Application for Planning Permission

Development: Erection of a 3-storey building comprising of under-croft car parking and bicycle store, 2 floors of 4 No self-contained flats on each (8 No flats in total) with pedestrian access formed onto Ash Grove. This application is in CIL Zone 4 (Zero Rated) as flats.

Location: Land East Of Heath Place Bersted PO22 9SL

Proposed Site Plan
1:200

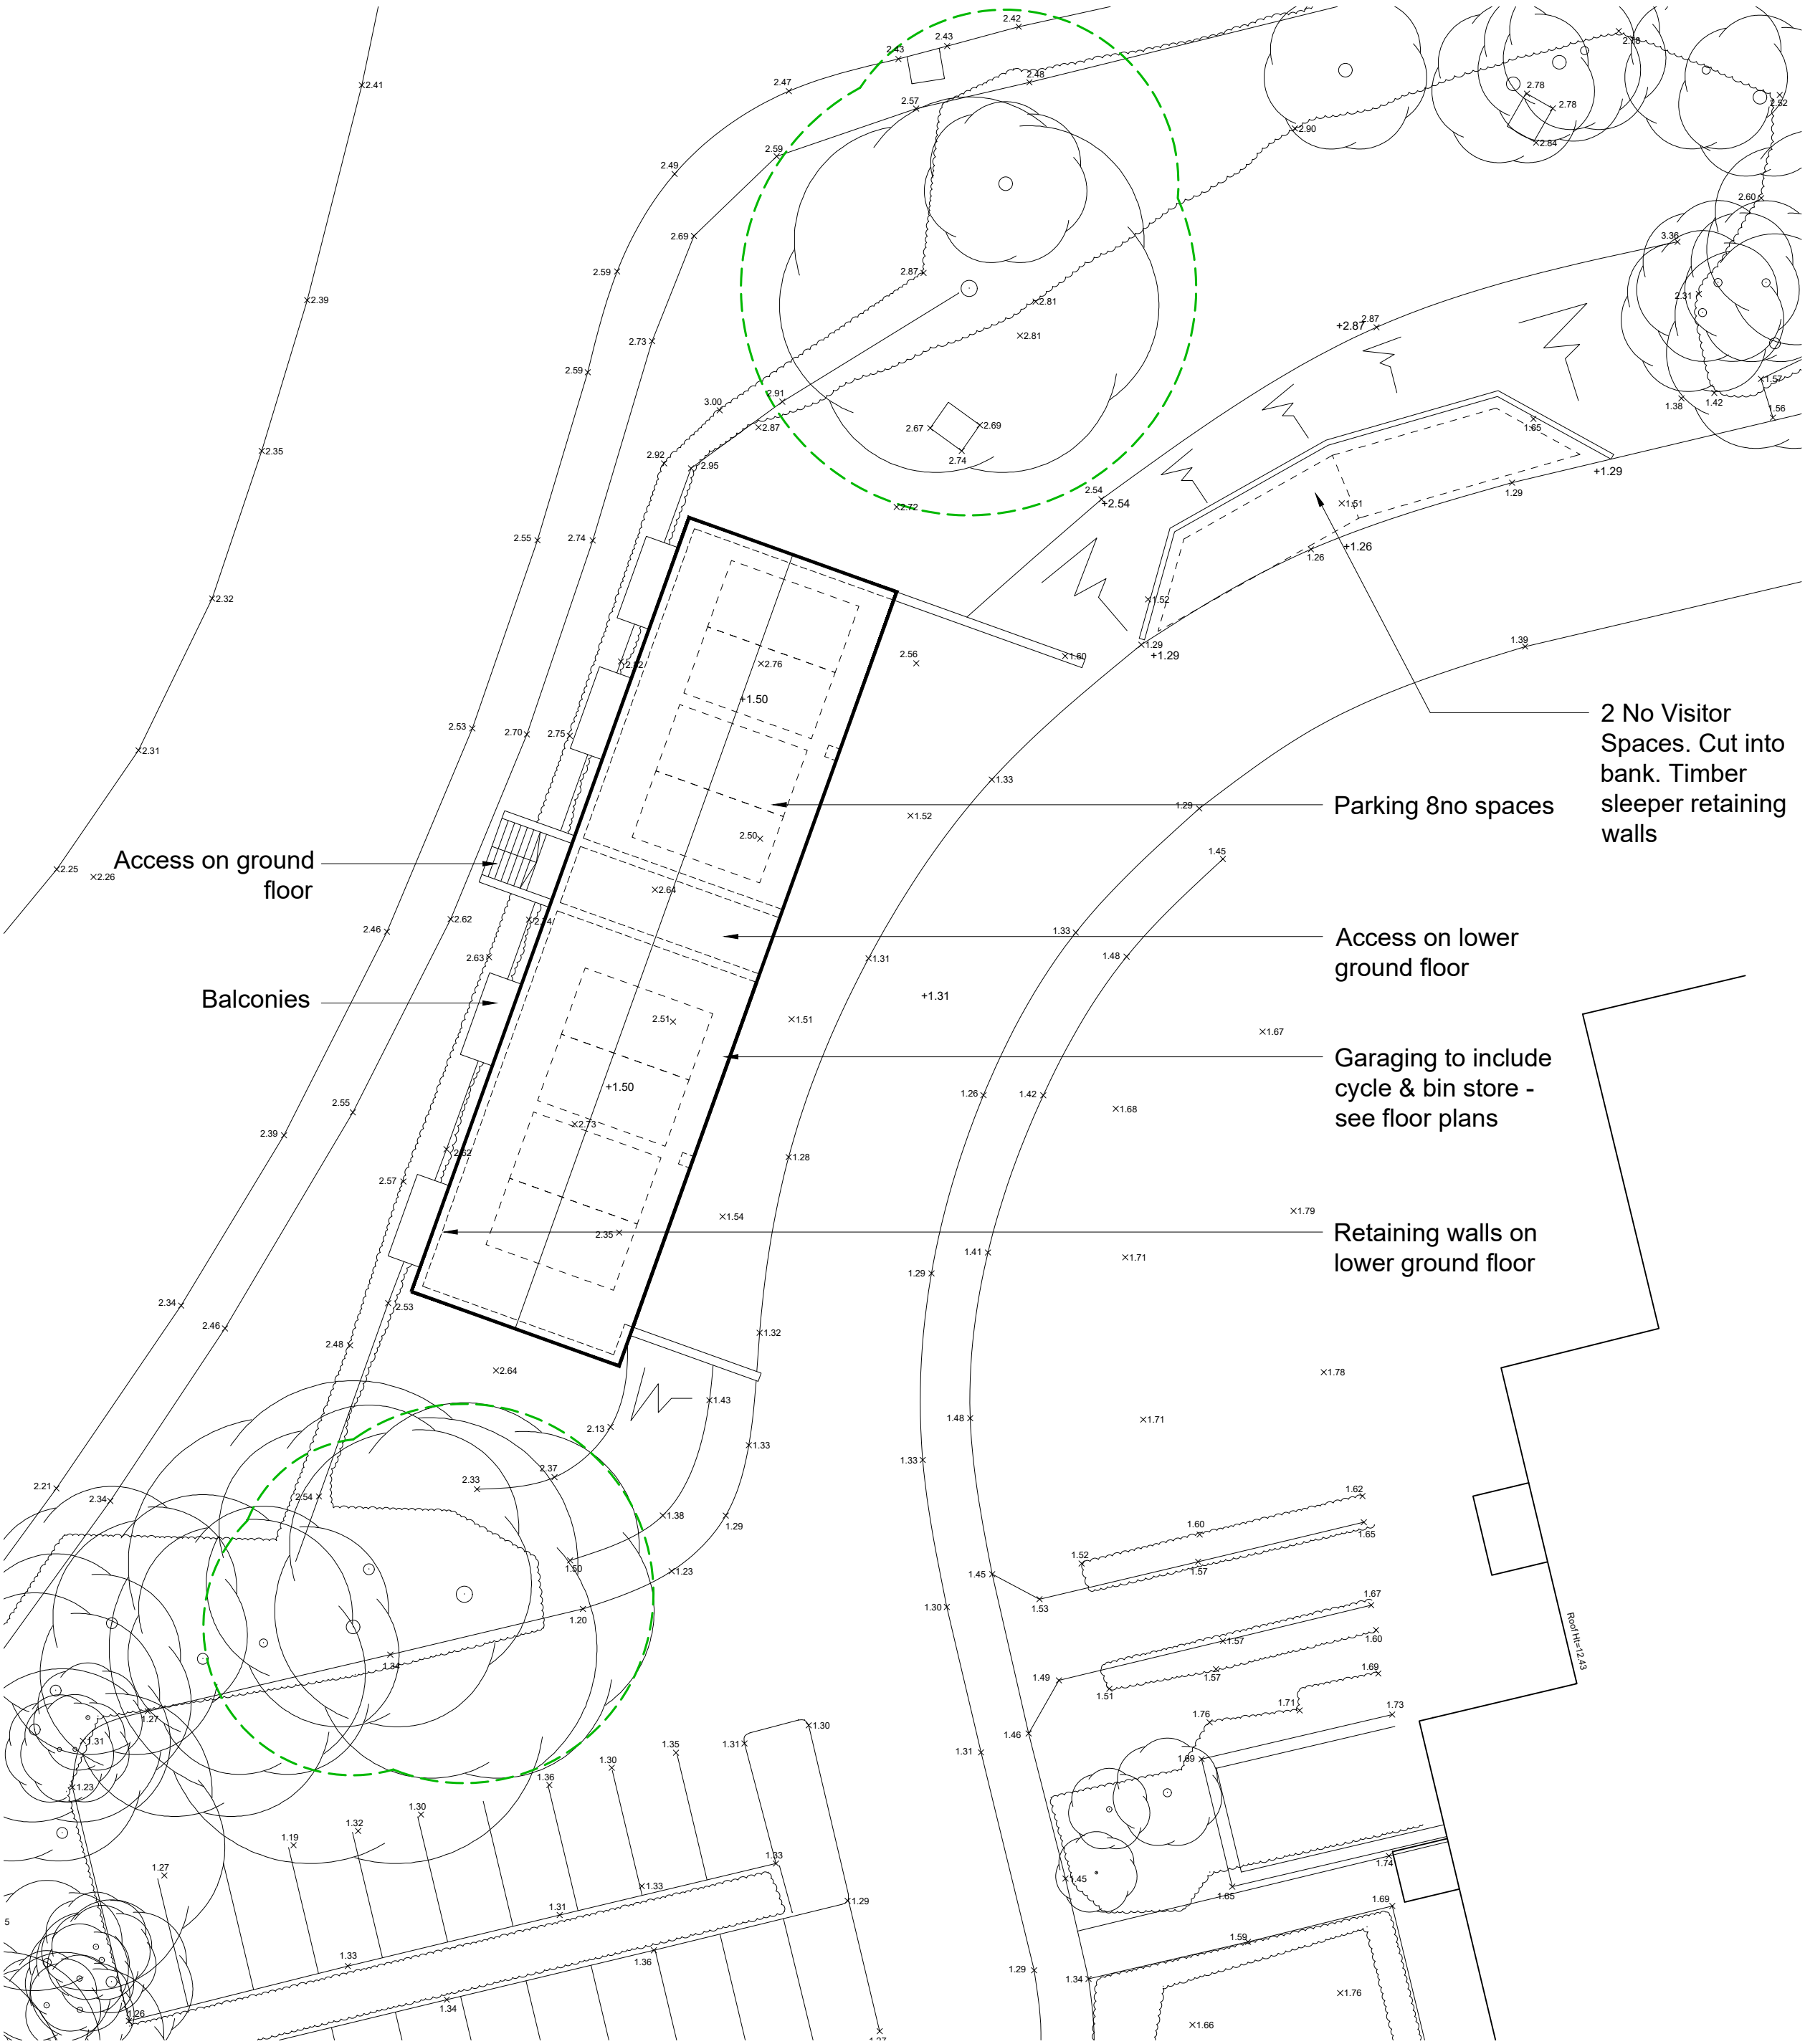
The application form states this proposal includes a new vehicle access from the highway. Please show the proposed access and visibility splays on the proposed site plan.

Location Plan

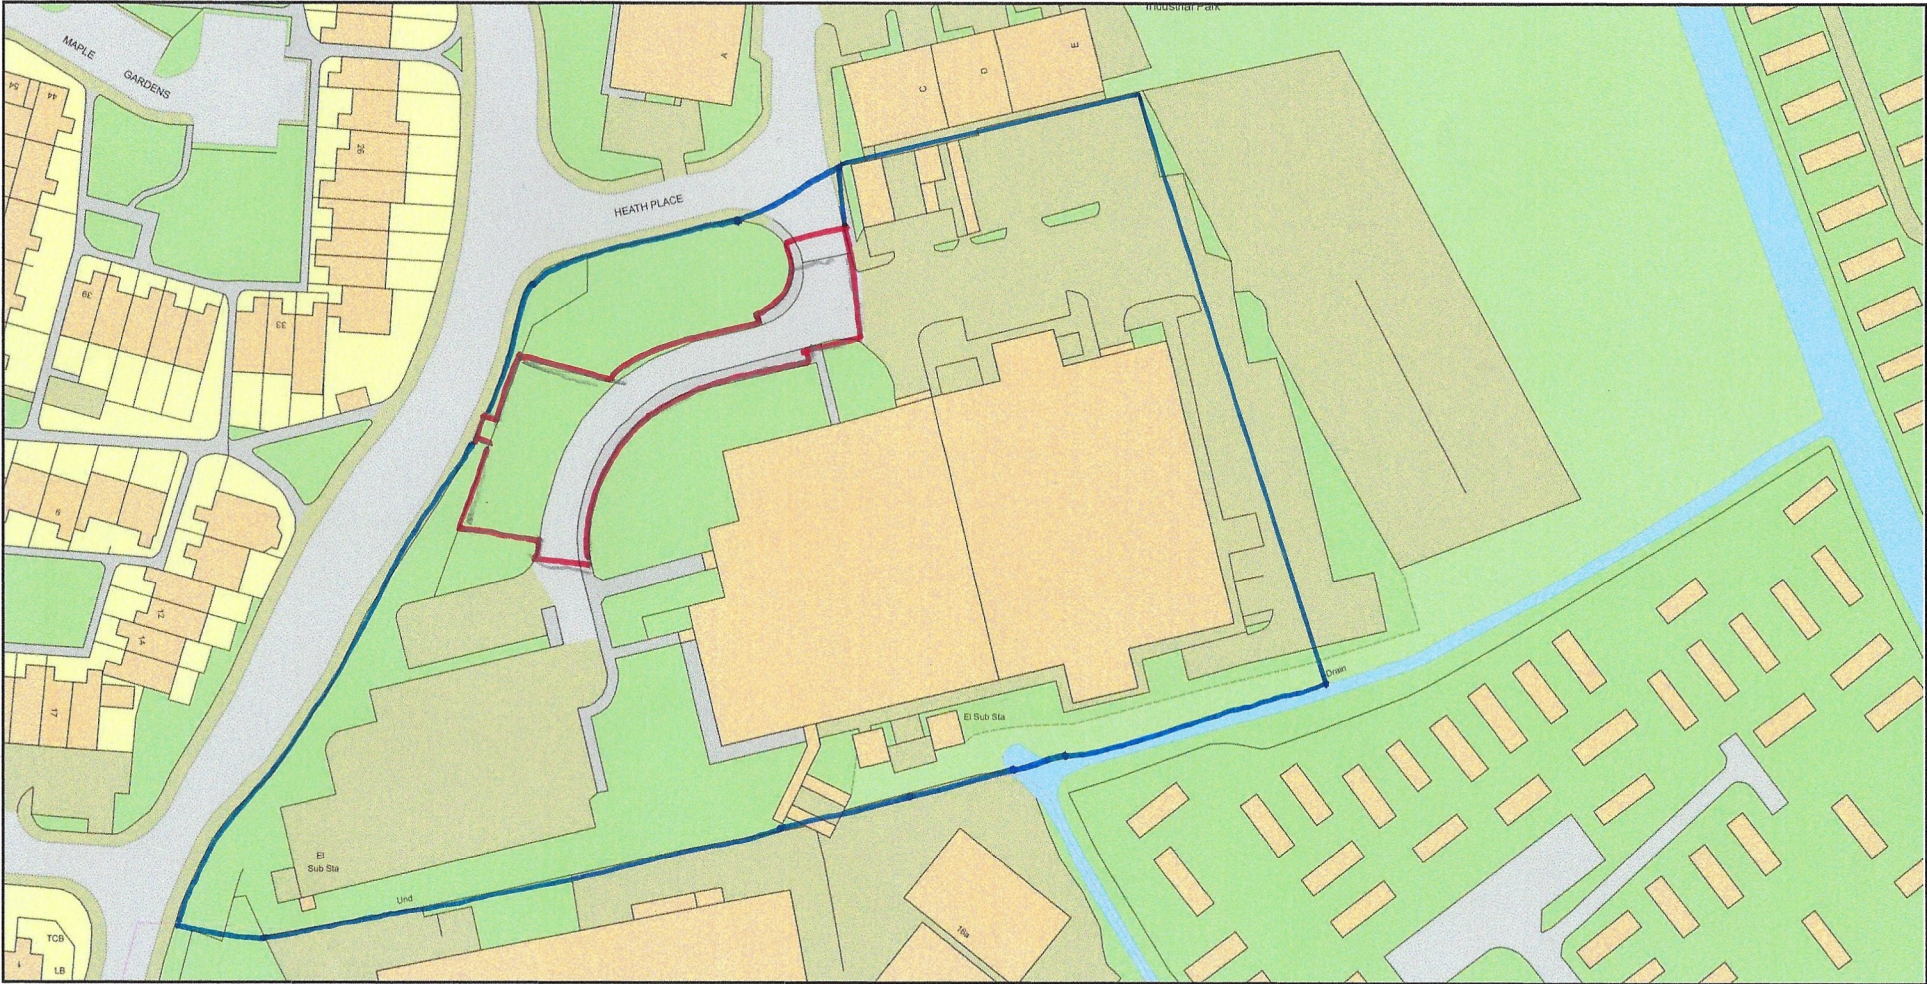
Location Plan

Please provide a full blue edge.
